RE: Storage Building – 4100 Yale NE
Grading Plan
Engineer Stamp Date: 11/24/17
Hydrology File: G16D095F

Based upon the information provided in your submittal received 11/27/2017, the Grading and Drainage Plan **is not** approved for Building Permit, Grading Permit, and SO-19 Permit. The following comments need to be addressed for approval of the above referenced project:

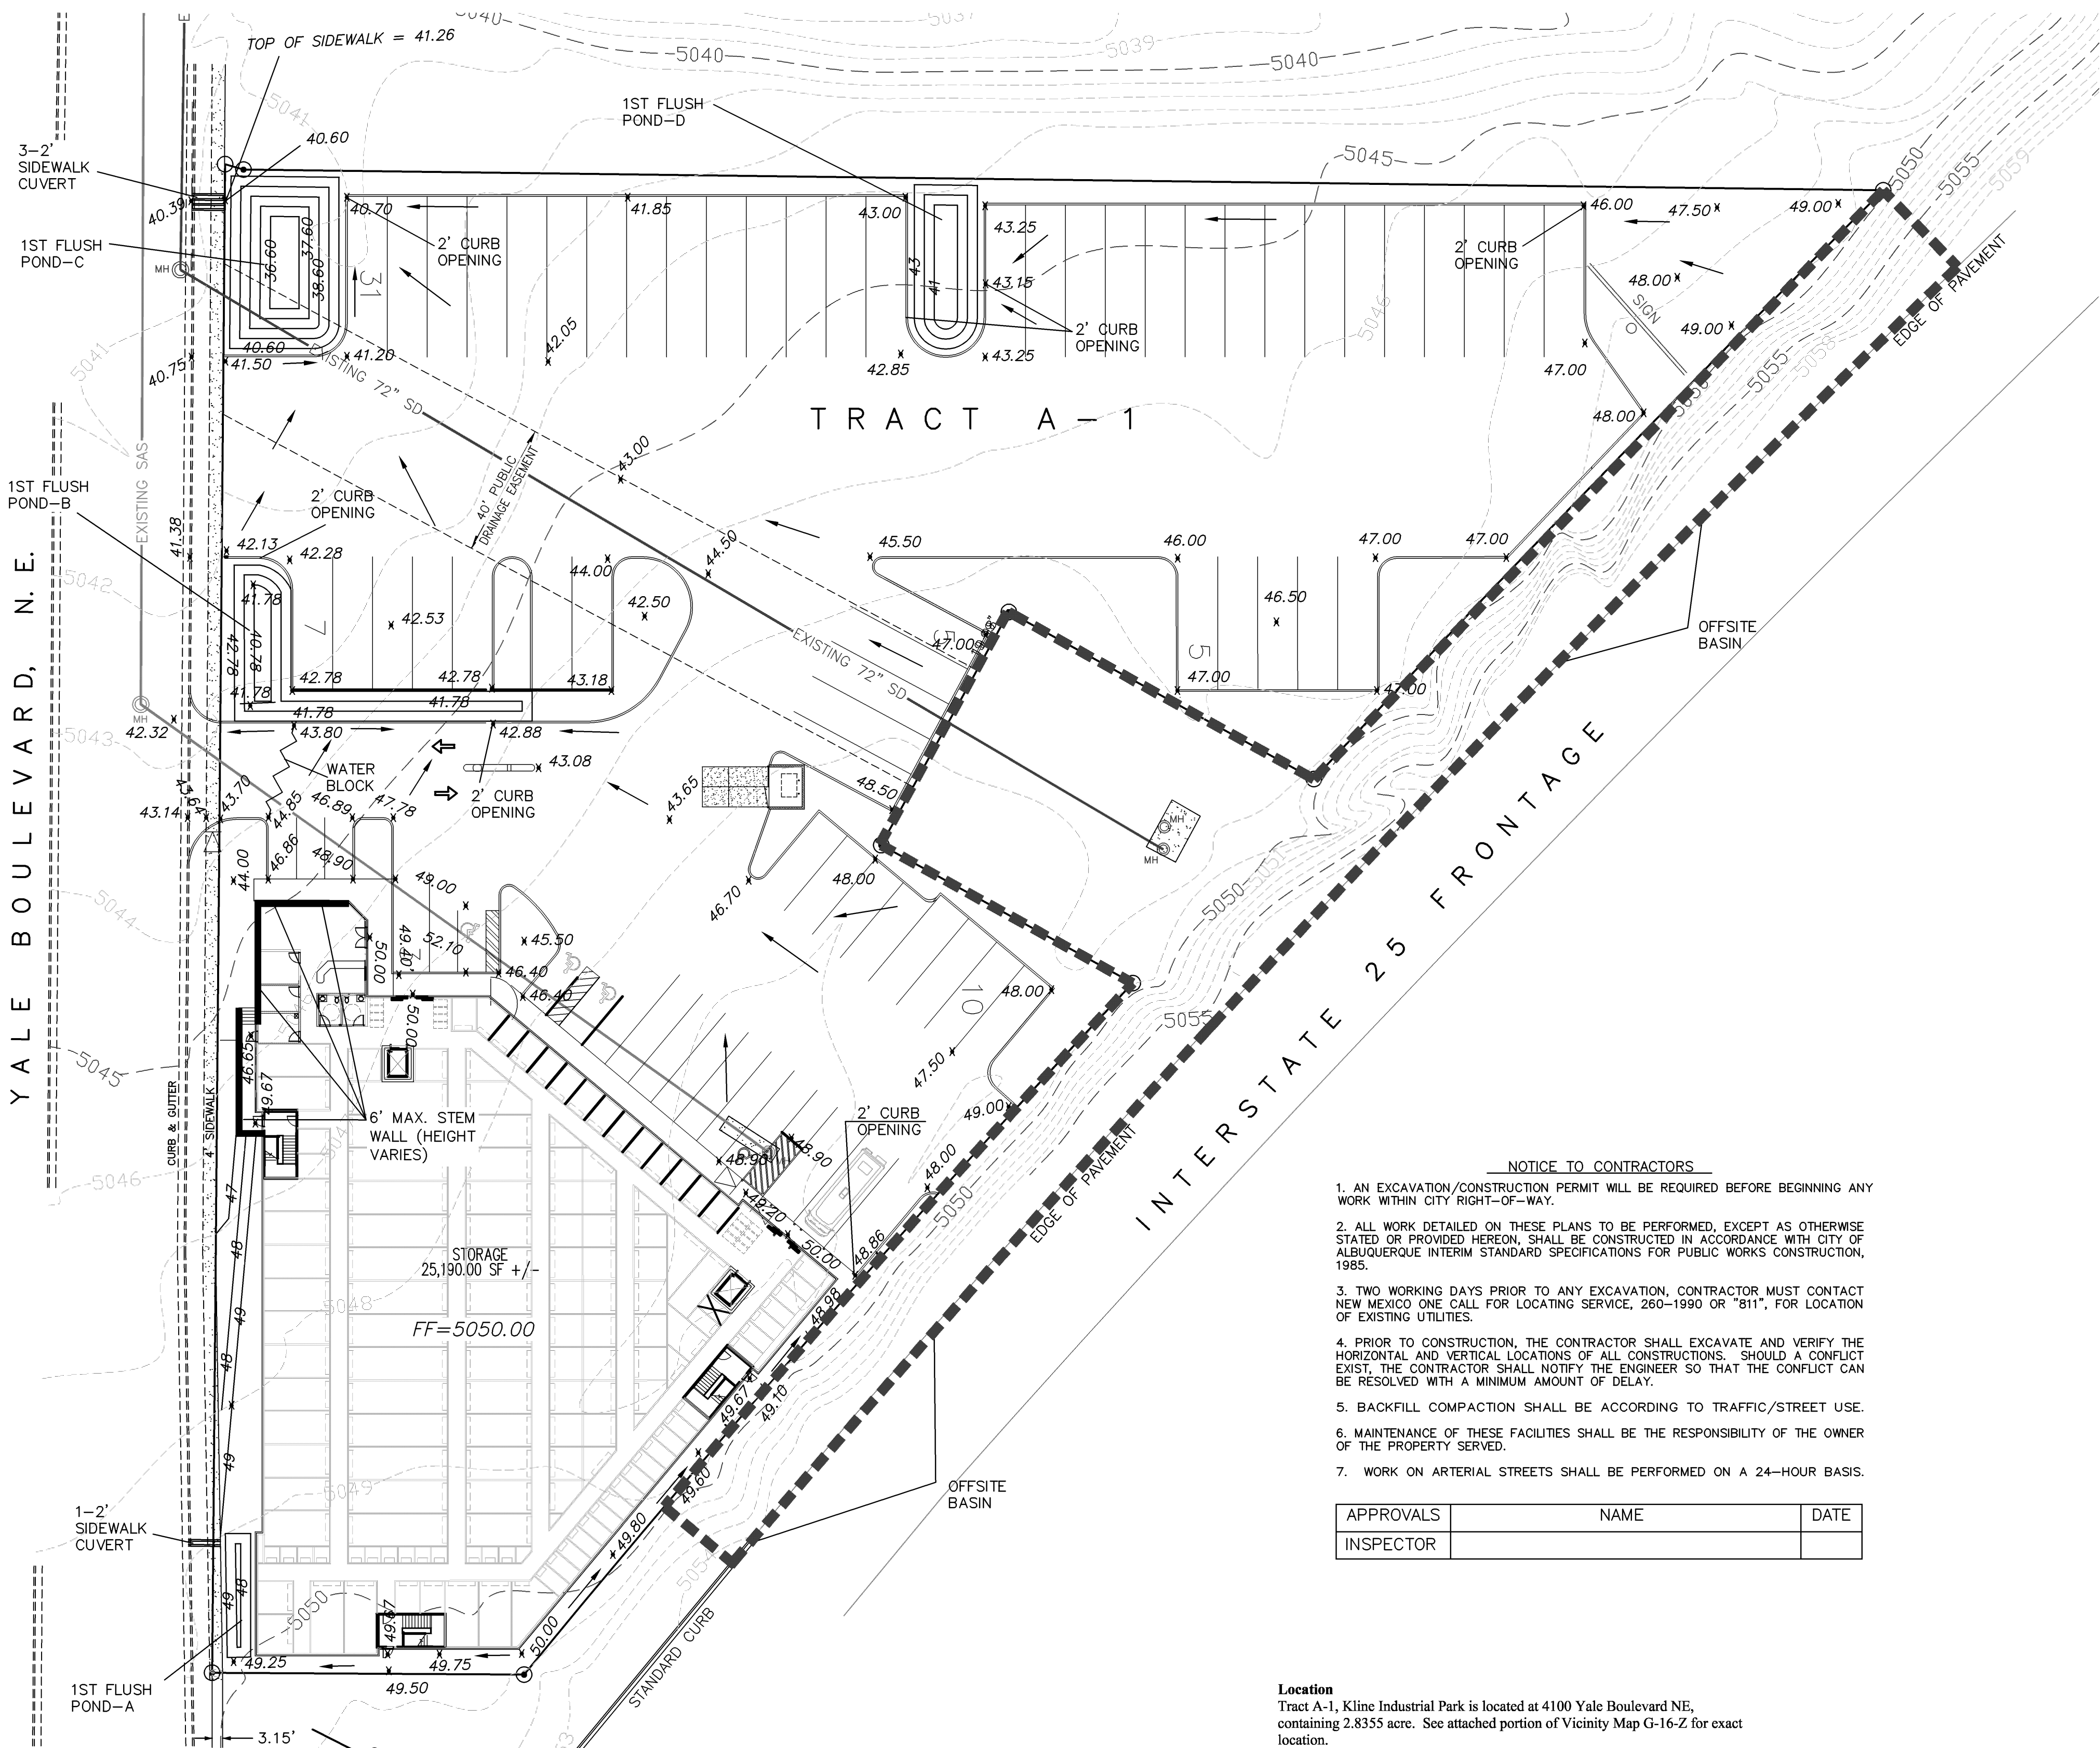
1. Please provide the flood plain effective date to the FIRM information.
2. Please provide the benchmark information for the survey contour information provided.

3. Please show and label the existing 40 feet drainage easement along the existing storm sewer pipe. See attached as-built plan & profile for the storm sewer.

4. Please label the existing storm sewer as “existing 72” public storm sewer”.
5. Please show the water block at the propose driveway.
6. Under the Existing Conditions, it talks about the offsite basin drains west to the site. This is true for portions of the offsite basin. However, there is an existing inlet where you show a piece of concrete. This picks up some drainage which ties into the existing 72” storm sewer. Also the interstate roadway drains to the east, away from the site. Please update both the off-site basin and the calculations for the flow that drains onto the site.

7. Please clean up the calculations. There is a line and overlapping text.

8. First Flush Ponds E, G, H, and J are all on the high side of the site. It is impossible to drain uphill to have these ponds function as first flush basins. Please relocate or consolidate in the ponds downhill where runoff can be treated.
